Subject: FW: Dappers Lane report - A/76/20/PL

Subject: FW: Dappers Lane report - A/76/20/PL

4. EVCP – As we have discussed previously there is a typing error in the SPD as shown in the table quoted by the applicant below. It should read that 100% of houses with a drive **OR** garage should have a designated EVCP. It has been agreed by Neil Crowther that this typo will be corrected and we should be asking for all houses with garage or driveway to be fitted with EVCP. I therefore stand by my original comments on this application.

KEY

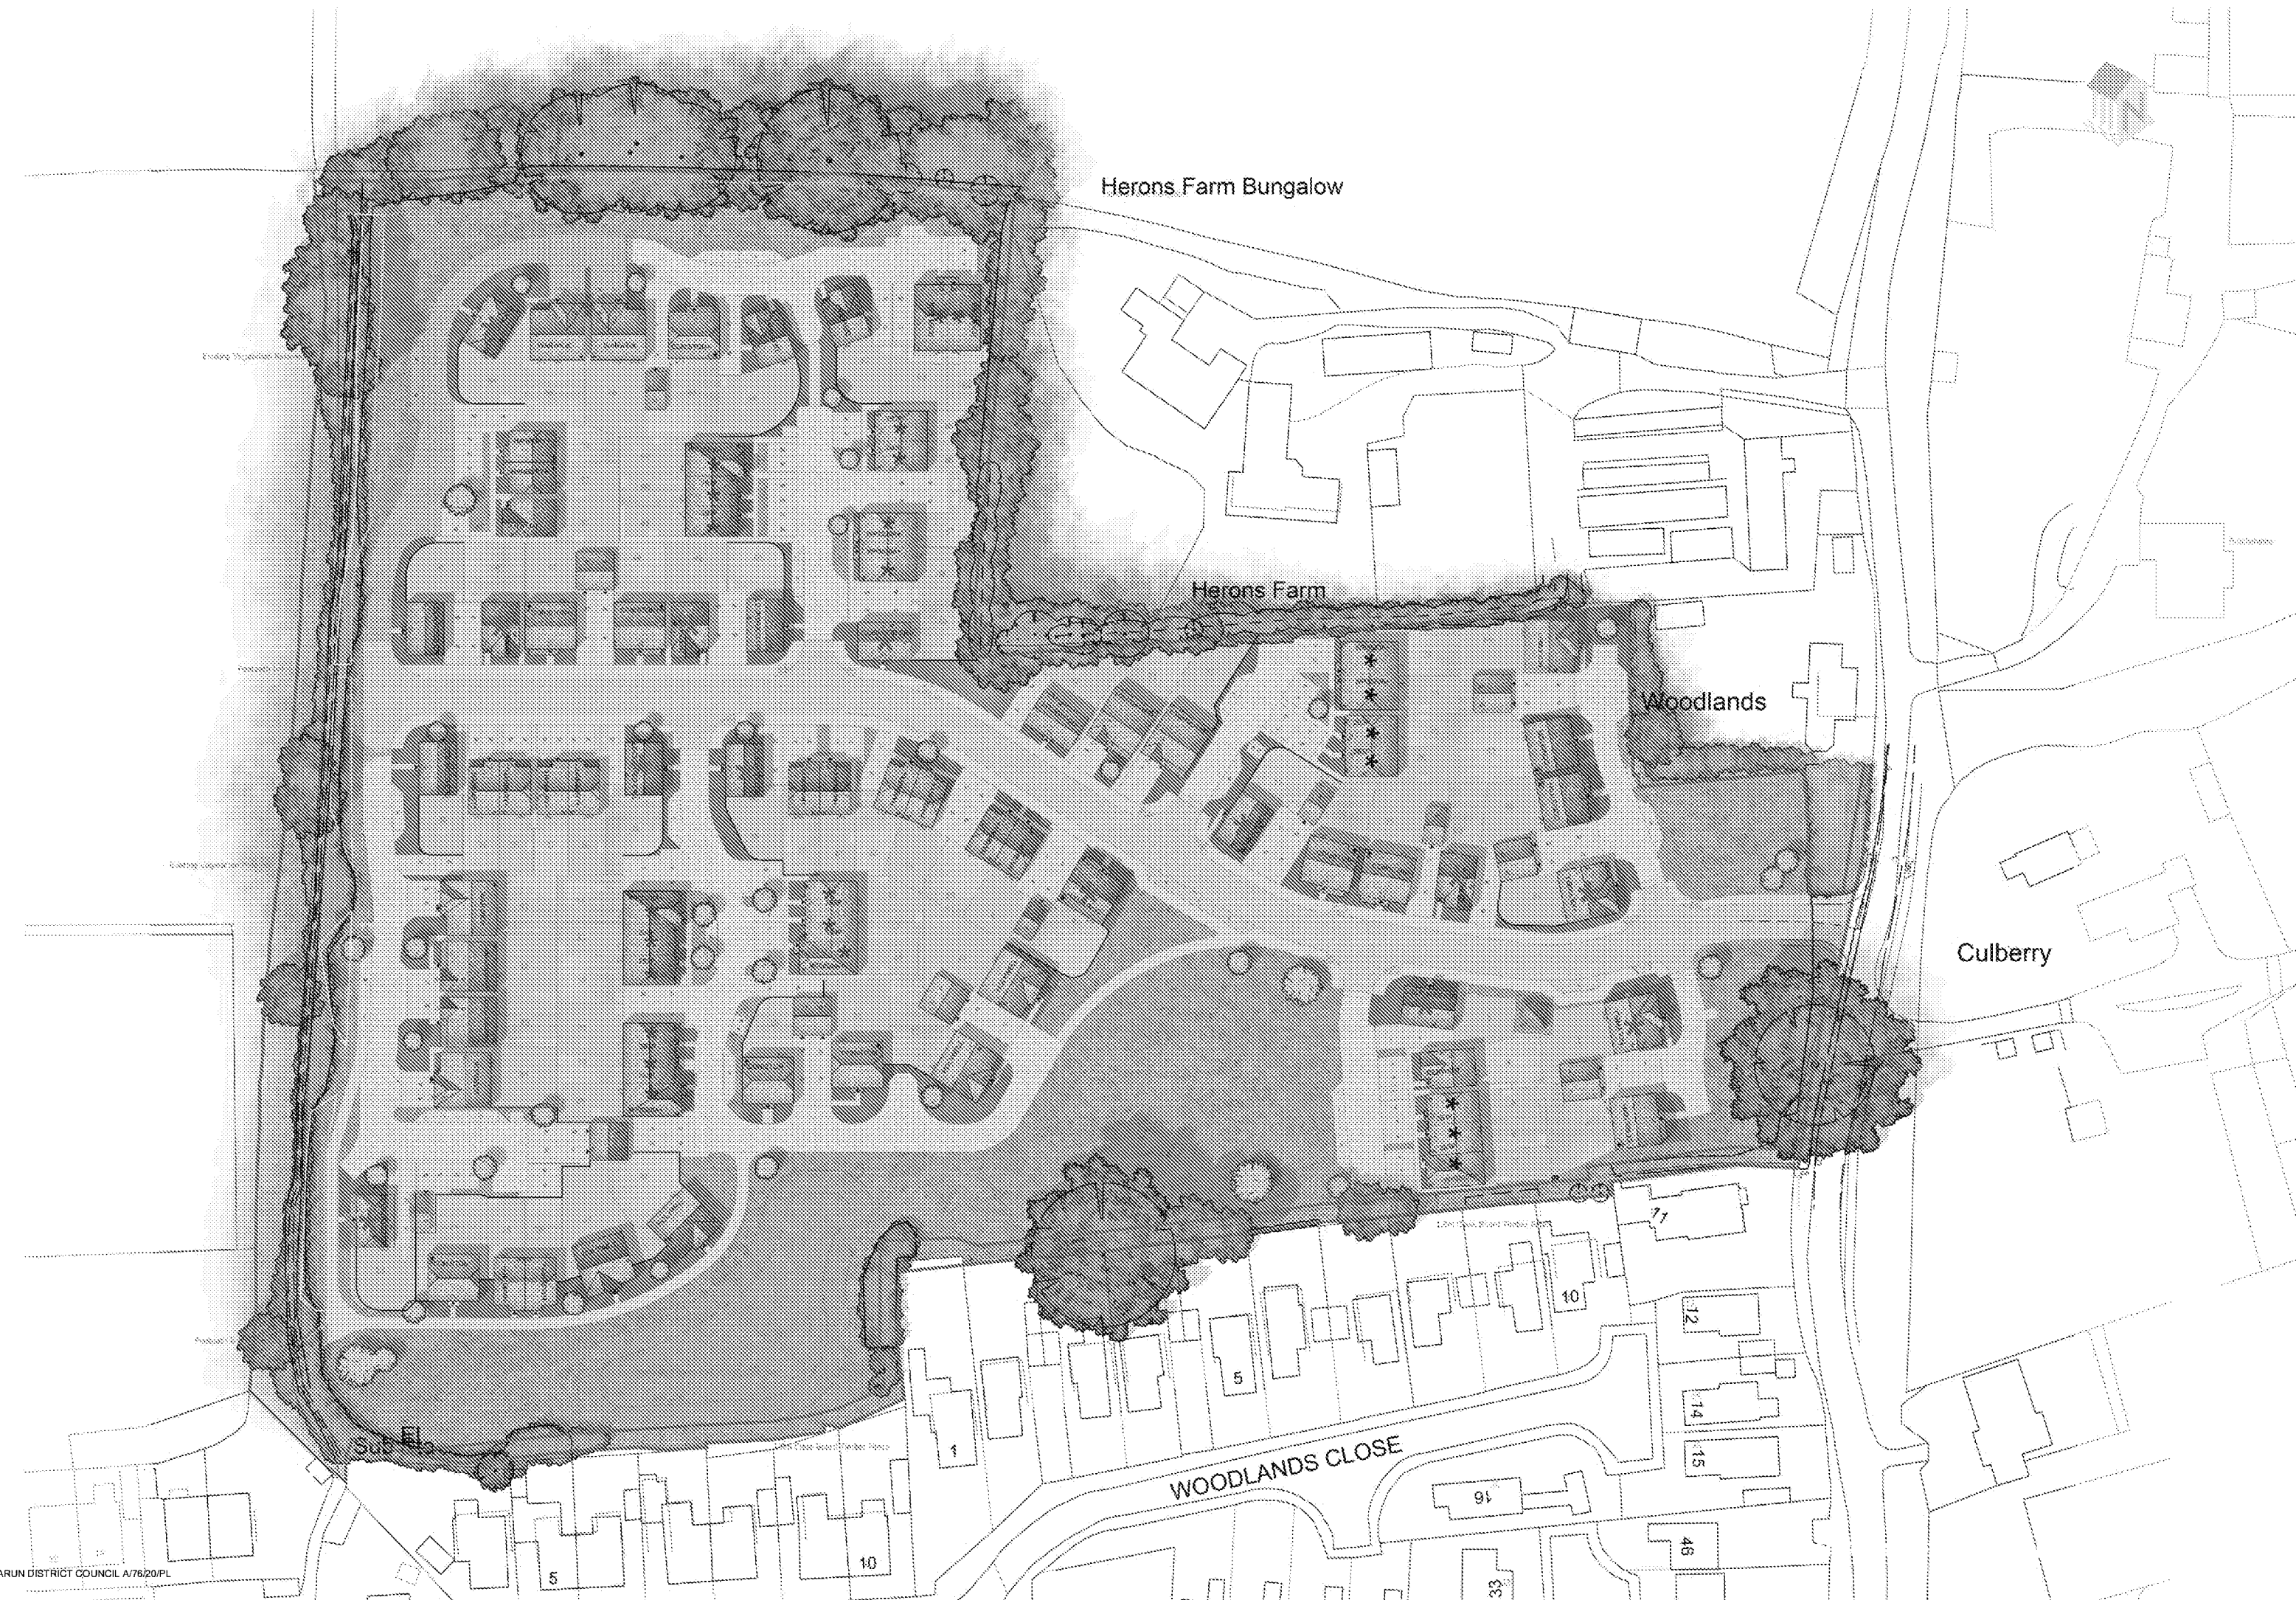
- External noise levels – acceptable
- Electrical substation - the assessment has not included the sub station shown on the submitted plans in the south western corner of the site.
